PRE-DEVELOPMENT APPLICATION

Pre-Development Application No:

PR2017/00010

50 Honeysuckle Drive Newcastle

5485 DA-0200 / 13

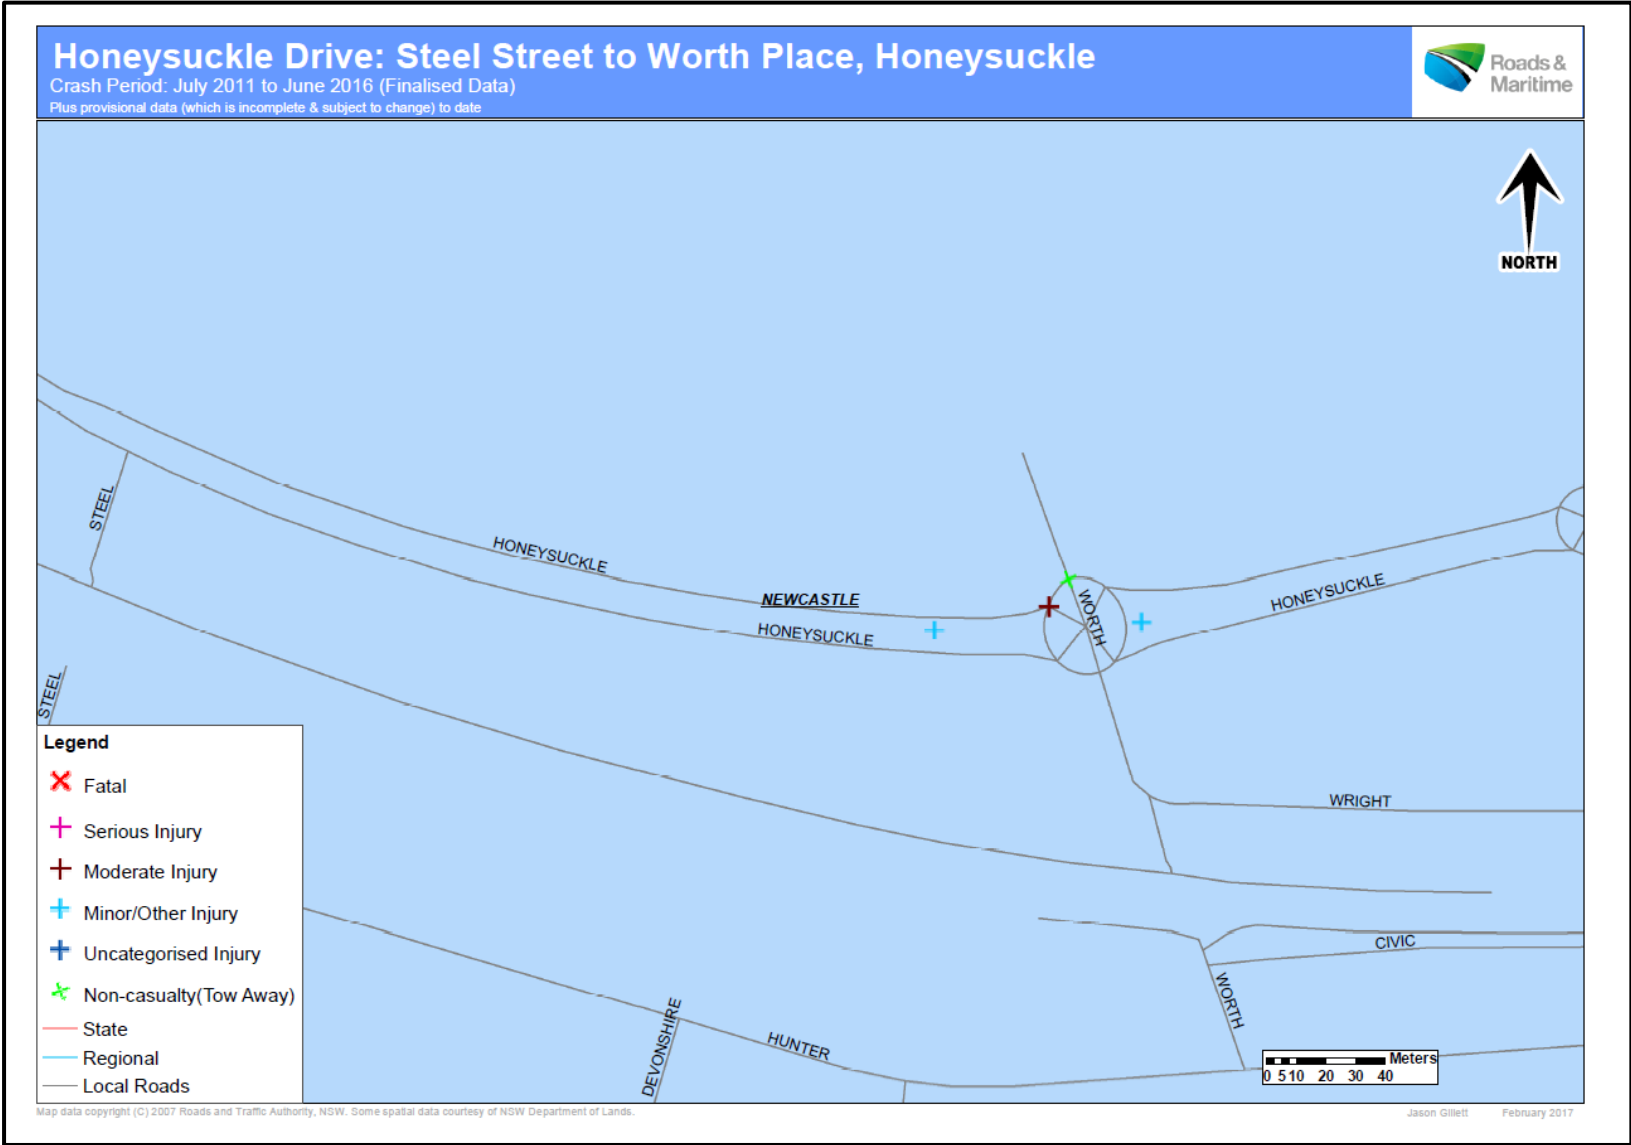
The submitted amended basement floor plan (Dwg.No.SK-DA-0200 Rev 10 dated 10 March 2017) indicates the following number of parking spaces:
